From: Jonathan Best <Jonathan.Best@arun.gov.uk>
Sent: 12 May 2026 16:10
To: Planning.Responses <Planning.Responses@arun.gov.uk>
Cc: Simon Brooksbank <Simon.Brooksbank@arun.gov.uk>
Subject: R/63/26/PL

The Windmill Inn and 34 Mill Lane Rustington BN16 3JN.

I have reviewed this application with regards to ecology and Biodiversity Net Gain.

Recommendation: I recommend holding this application until further details are provided on the BNG metric and roosting bats.

Post-Development Plan

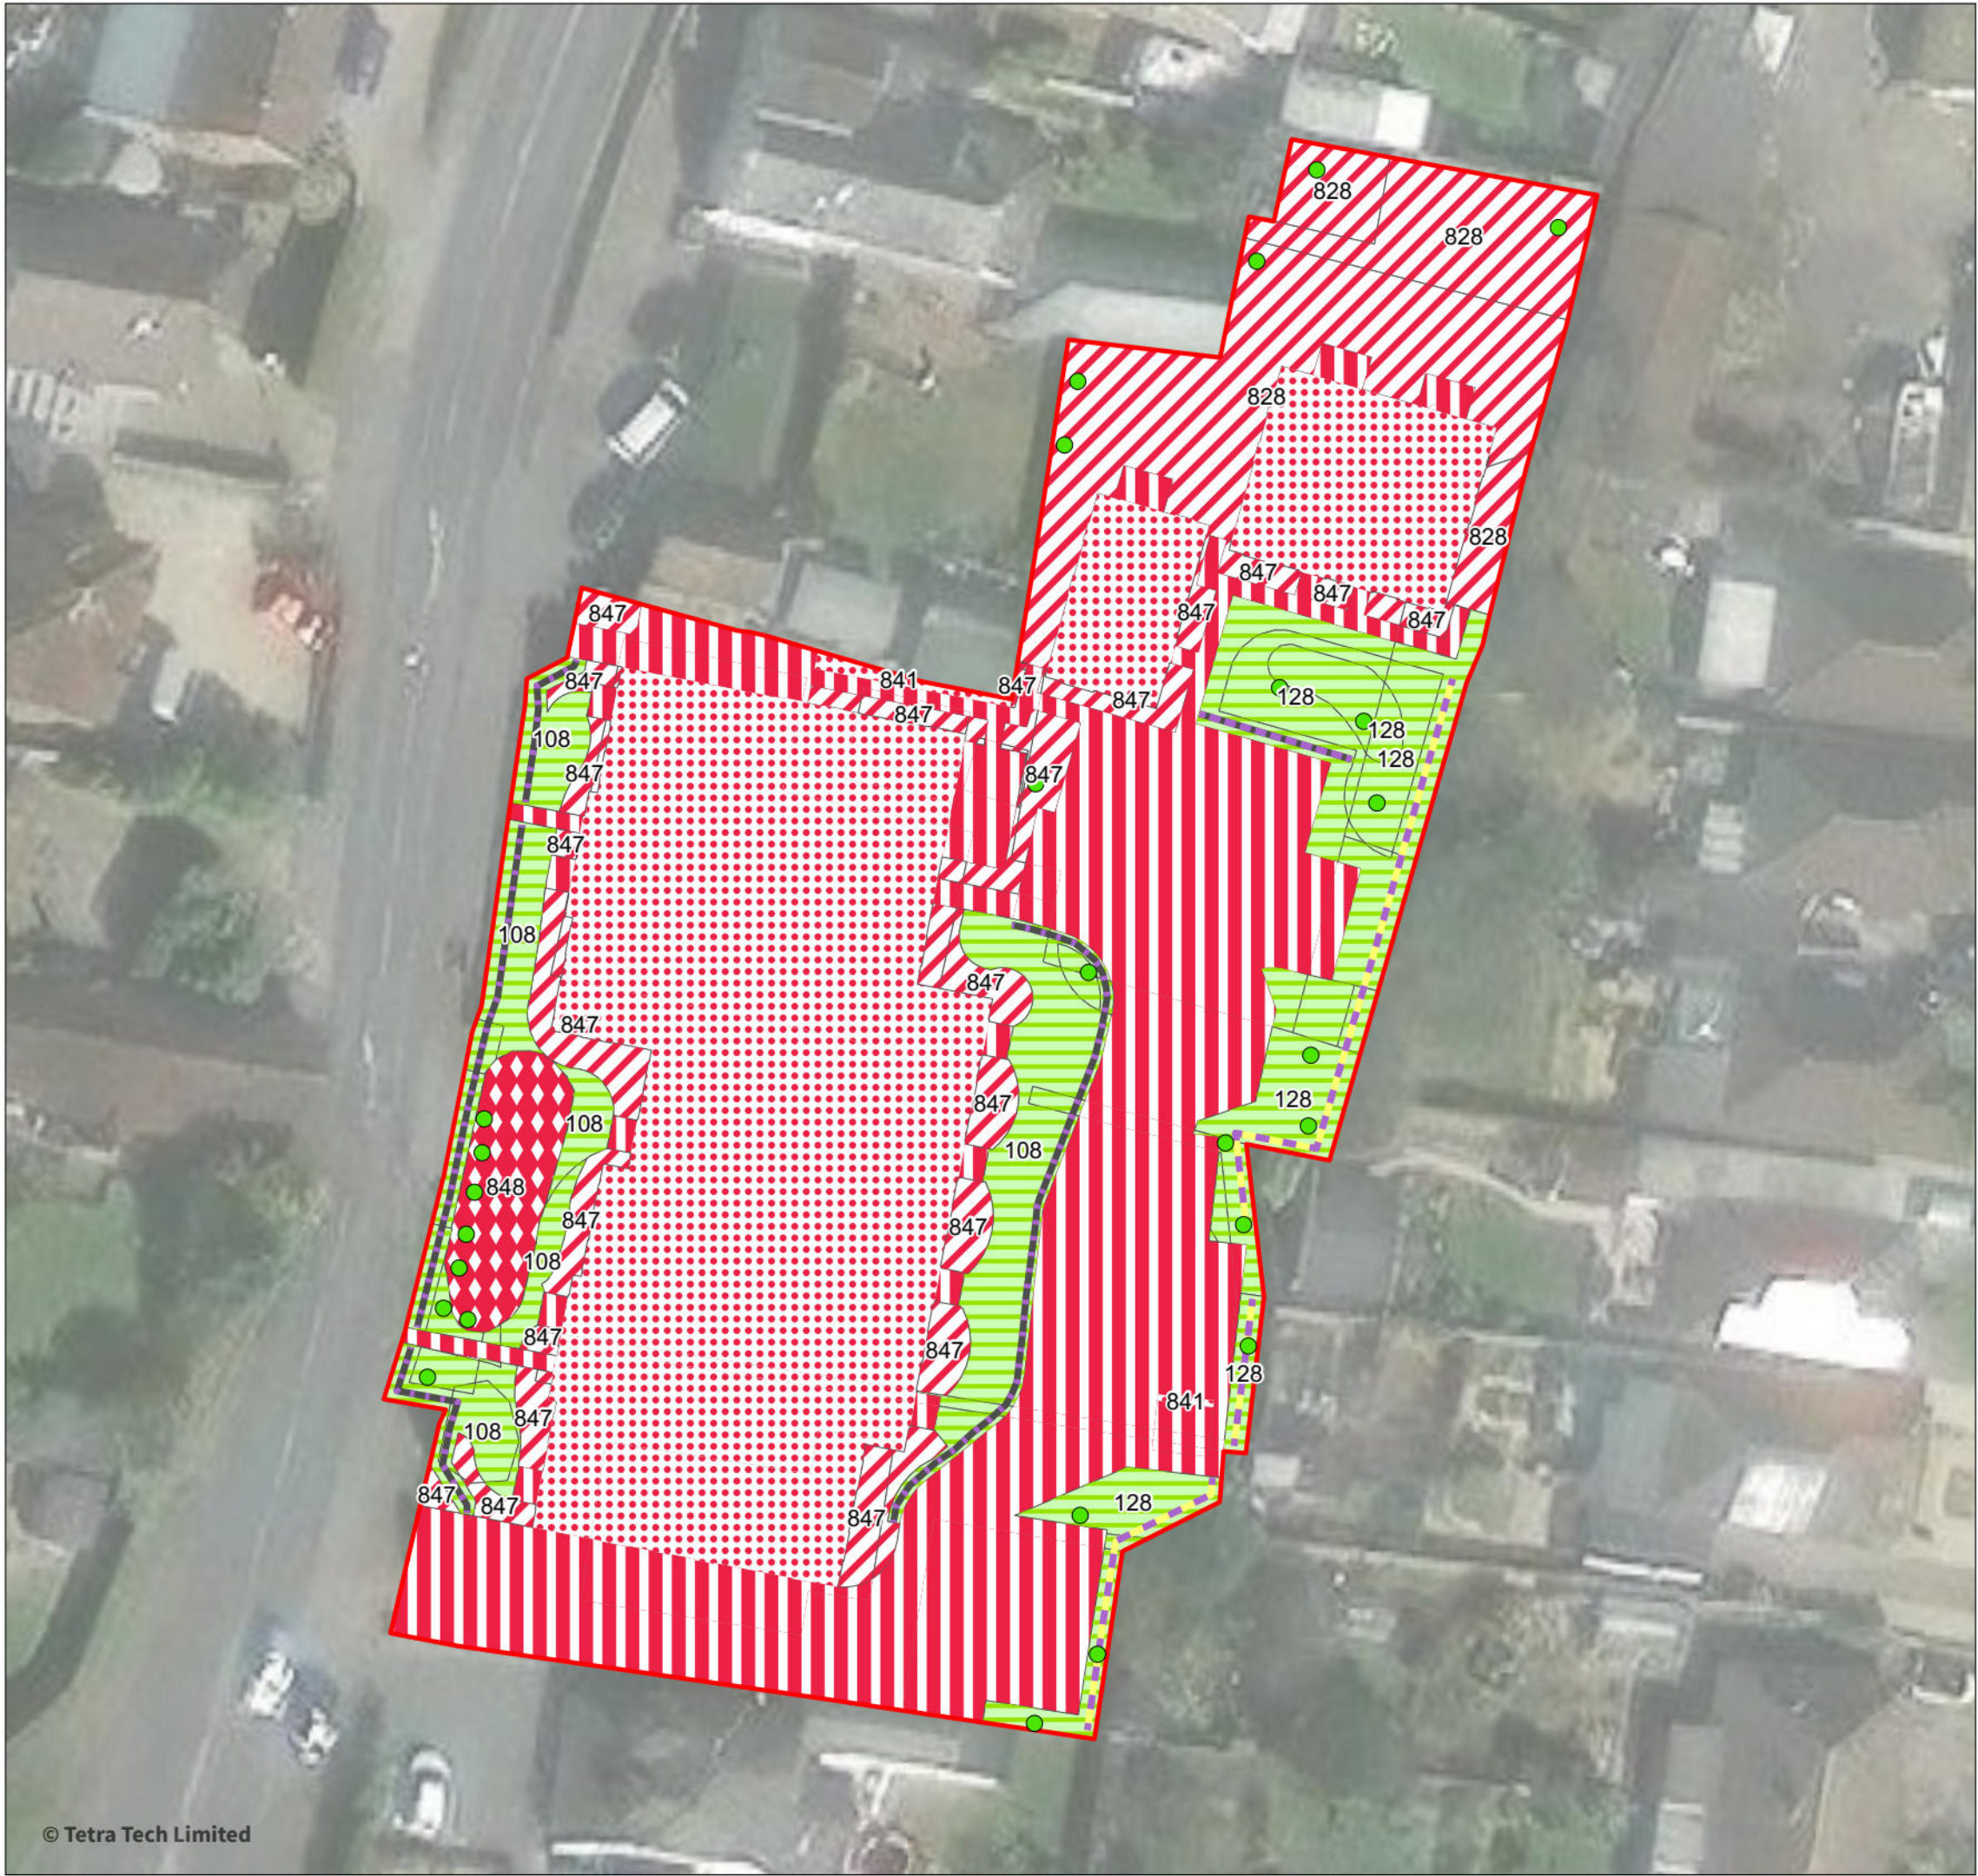
The Metric notes 4 trees in the baseline. Trees T1 and T2 are not accounted for in the metric. These trees are marked for felling in the arboricultural impact assessment and should be included and recorded as not retained.. Tree 5 is given a value of 0.016 but has a stem diameter of 57.5 so should be listed as 0.036. T1 is small so 0.0041 and T2 is 0.036 as its diameter is 32.5. This will change the value of the BNG calculations. An updated metric is required.
